12 February 2014

**RE Modification Request Cronulla Marina Tonkin Street, Cronulla
 MP06_0063 MOD1**

**Figure 4-4 Northern photomontage view of the proposed development (Source: Innovative Architects)**

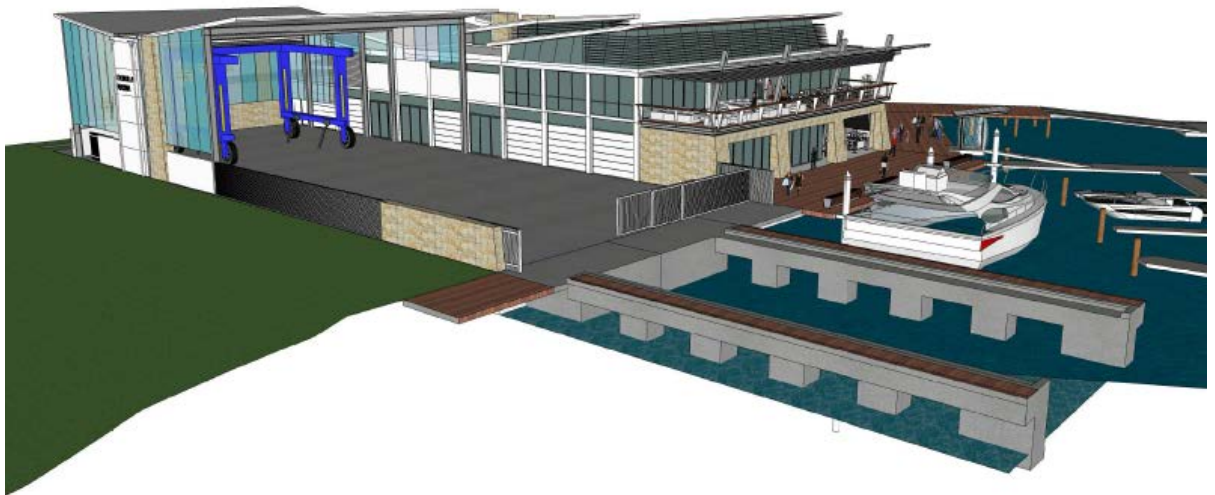
The photomontage above shows only a relatively low fence/wall along the northern boundary. If built as shown, there will be a considerable drop (up to approximately 2m) below the fence/wall to the natural shore below.

Drawing Title  
**SITE ANALYSIS / ROOF PLAN**

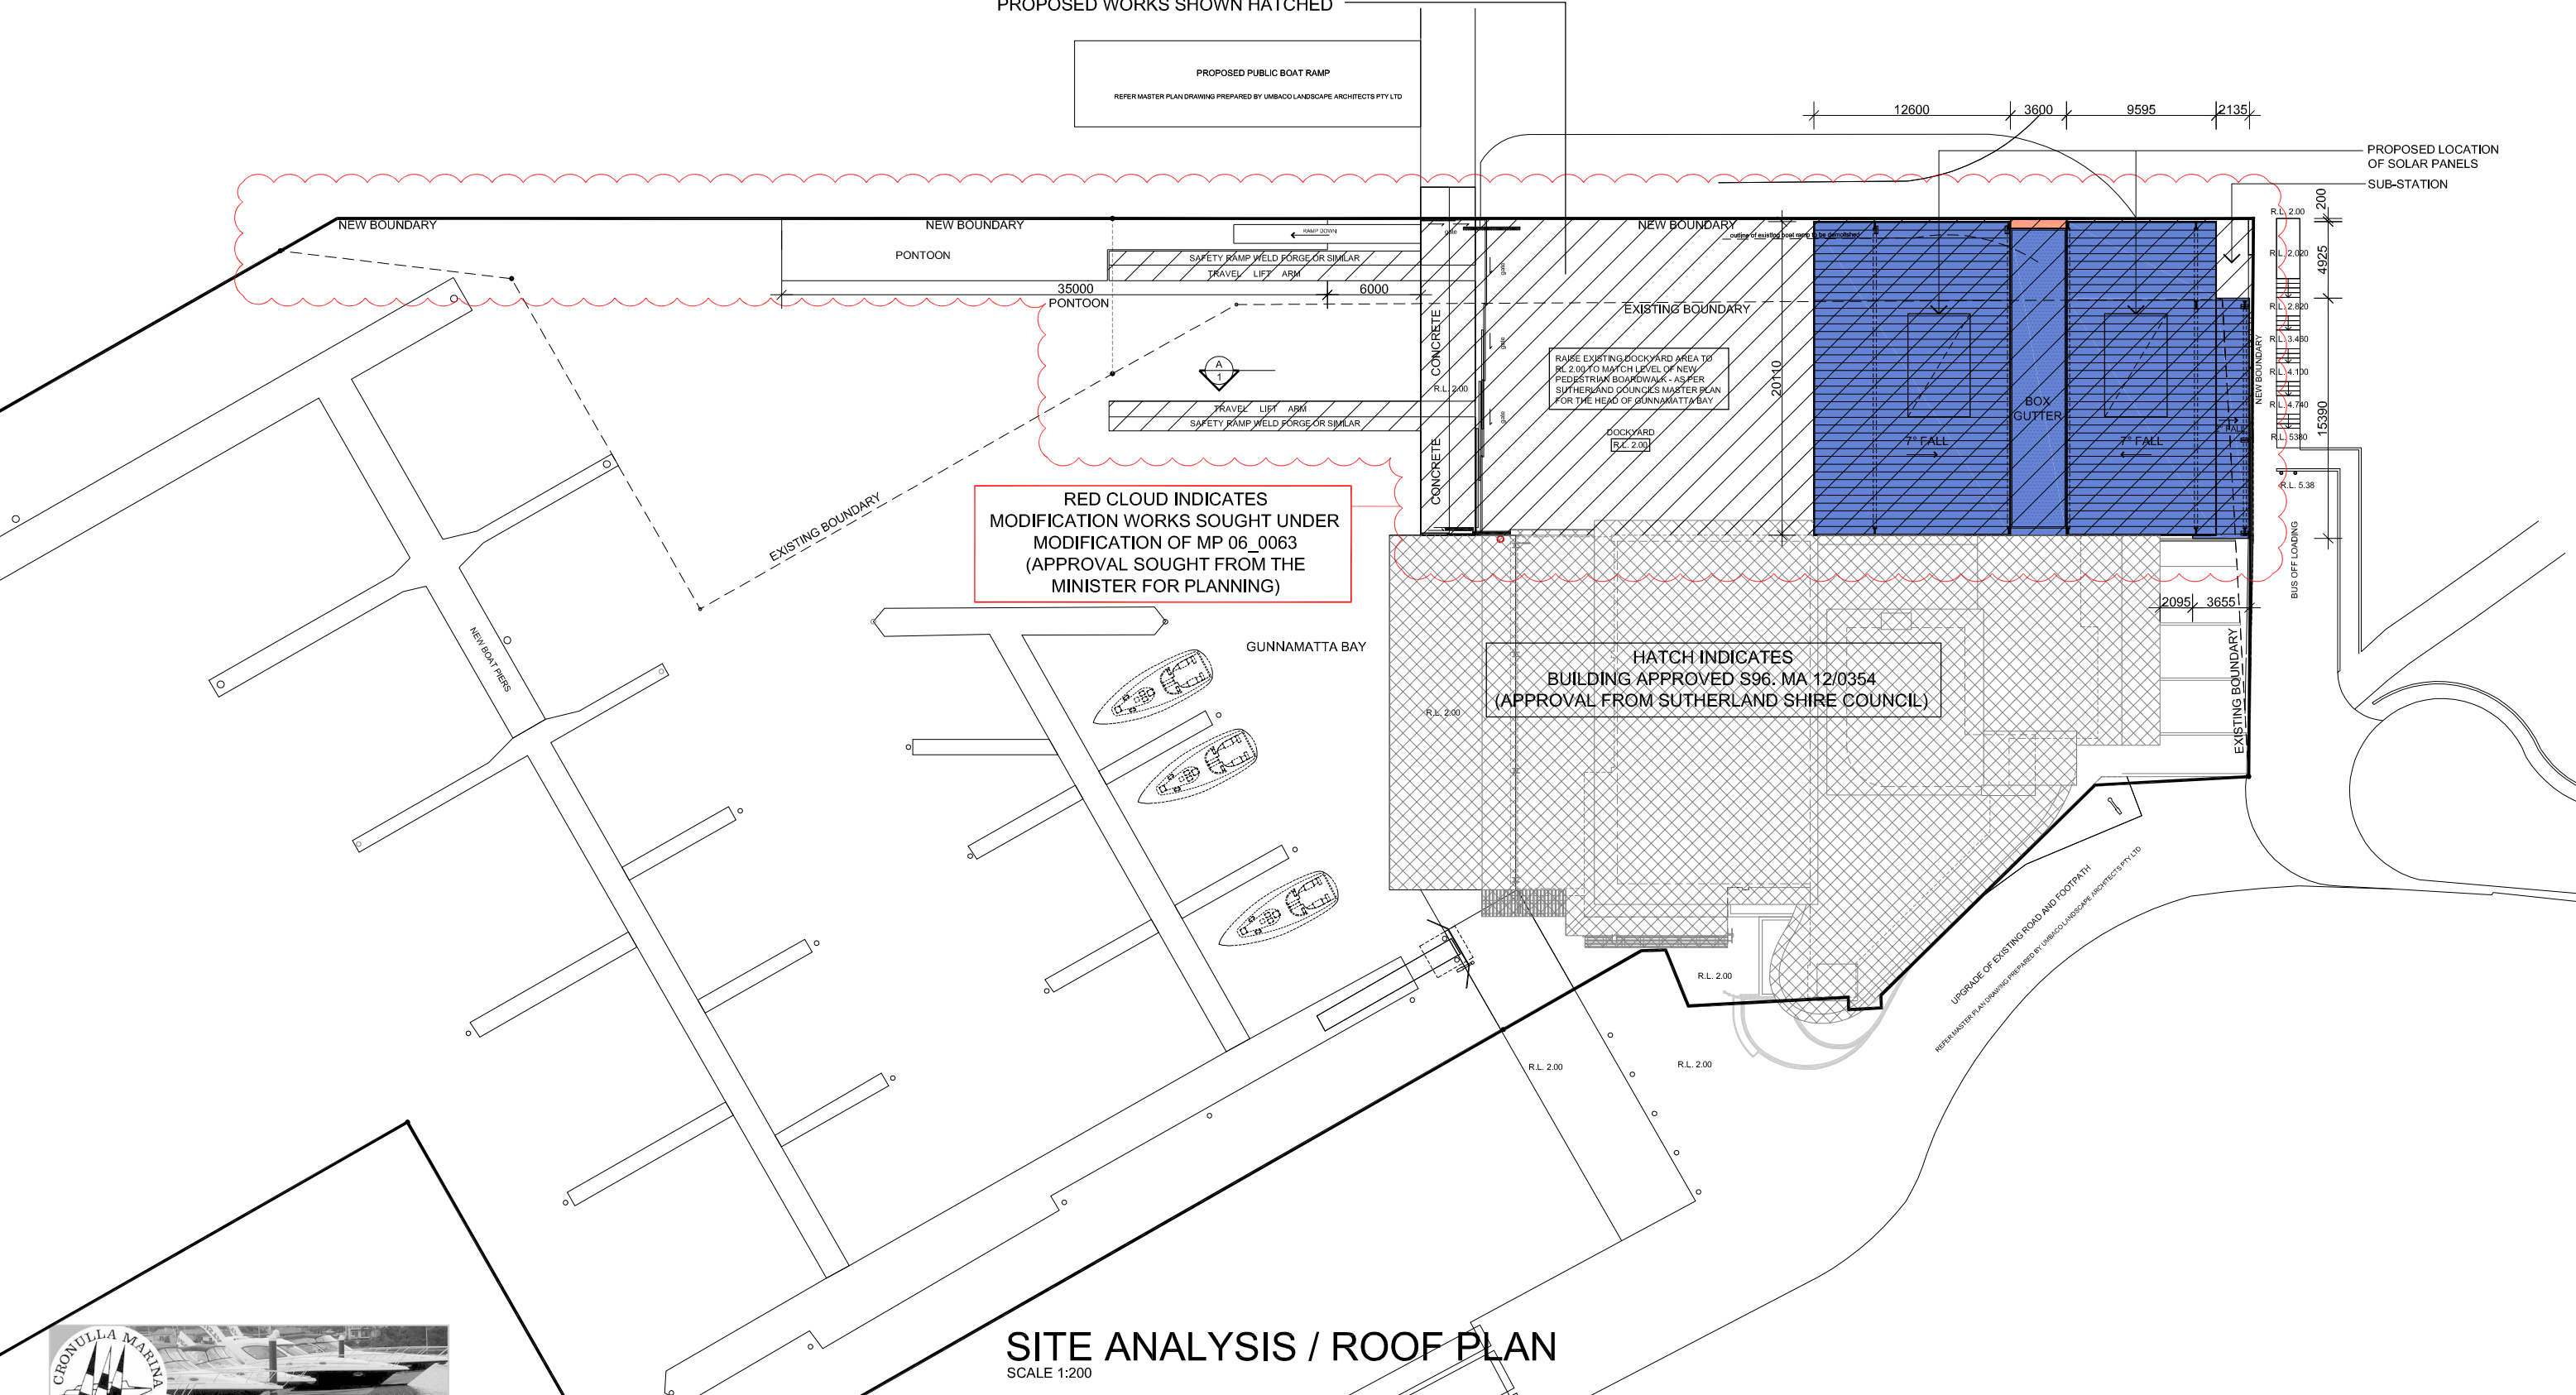
It is not clear from studying the Section 75W Modification Request - Statement of Environmental Effects what has happened to the area where the floating pontoon is located in the existing approval. It is shown in some of the photomontages in the old location. It is also not clear what would be built where the pontoon is currently approved. The Section 75W Modification Request - Statement of Environmental

Effects Part 1 SITE ANALYSIS / ROOF PLAN drawing shows the area approved by Sutherland shire Council at RL 2.0 but the current approval for the slipway shows it as a pontoon (see Approved Site Plan extract above).

These numbers are calculated with reference to drawings "SITE ANALYSIS / ROOF PLAN" and "GROUND FLOOR PLAN in the document: Section 75W Modification Request - Statement of Environmental Effects Part 1

**SIDE ELEVATION (north)**  
SCALE 1:100 @A1

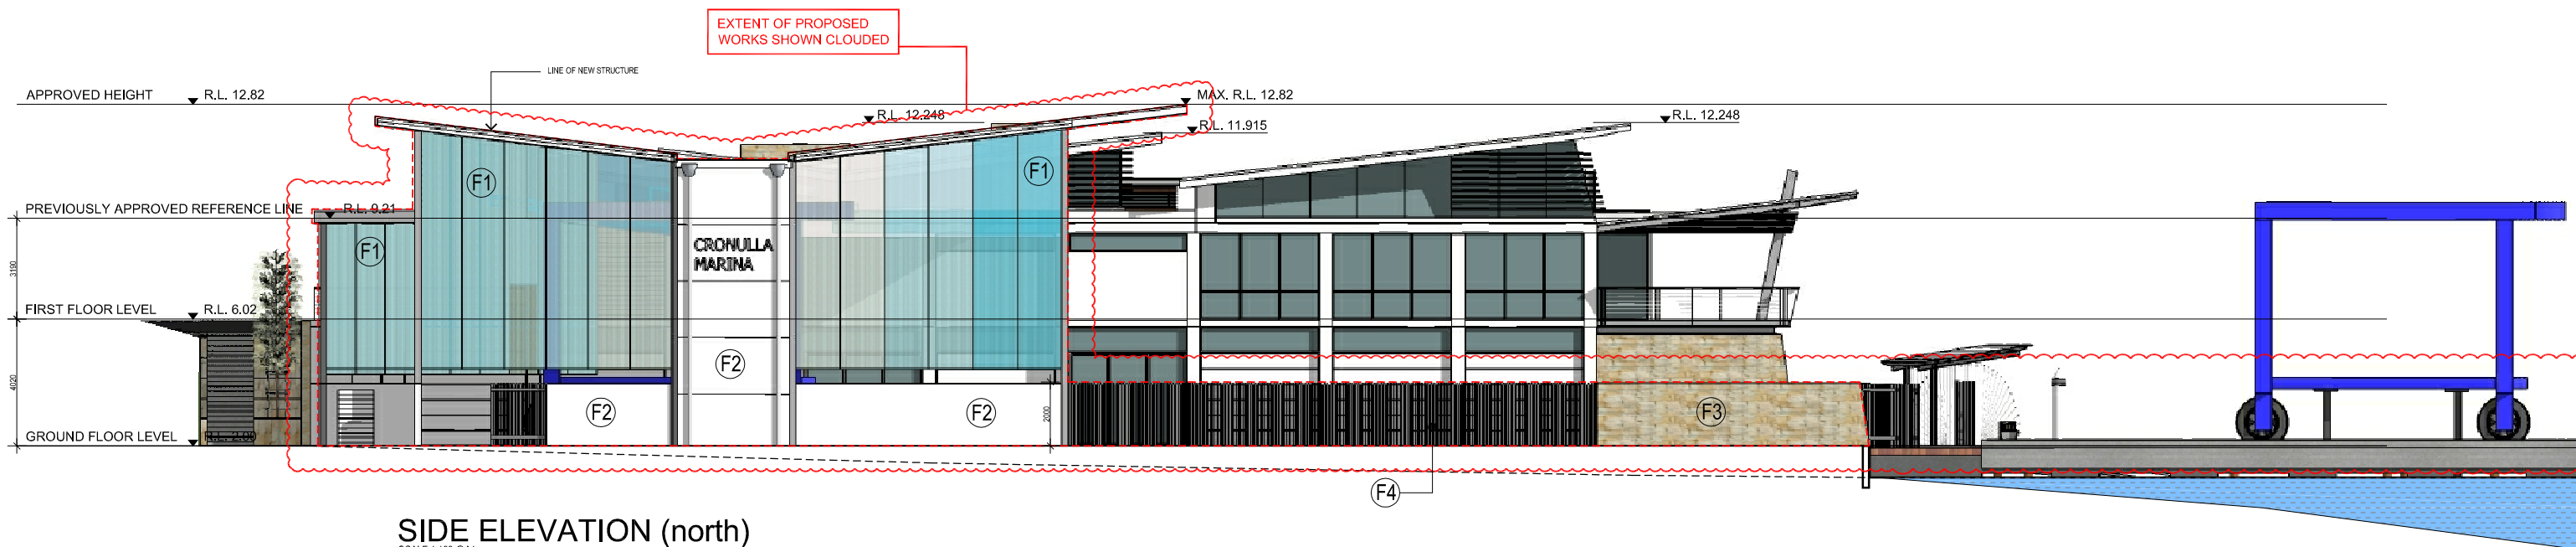
The visual impact of the travel lift arms and the RL2.0 hardstand area should not be underestimated, especially when viewed from the north.

There is currently a sloping slipway. This slipway approximates the natural shore profile and does not have a large visual impact when viewed from the scenic head of Gunnamatta Bay. The travel lift arms extend a long way out and need to be level. They make a very large visual impact, especially at low tide when they may be up to 2 meters above the water.
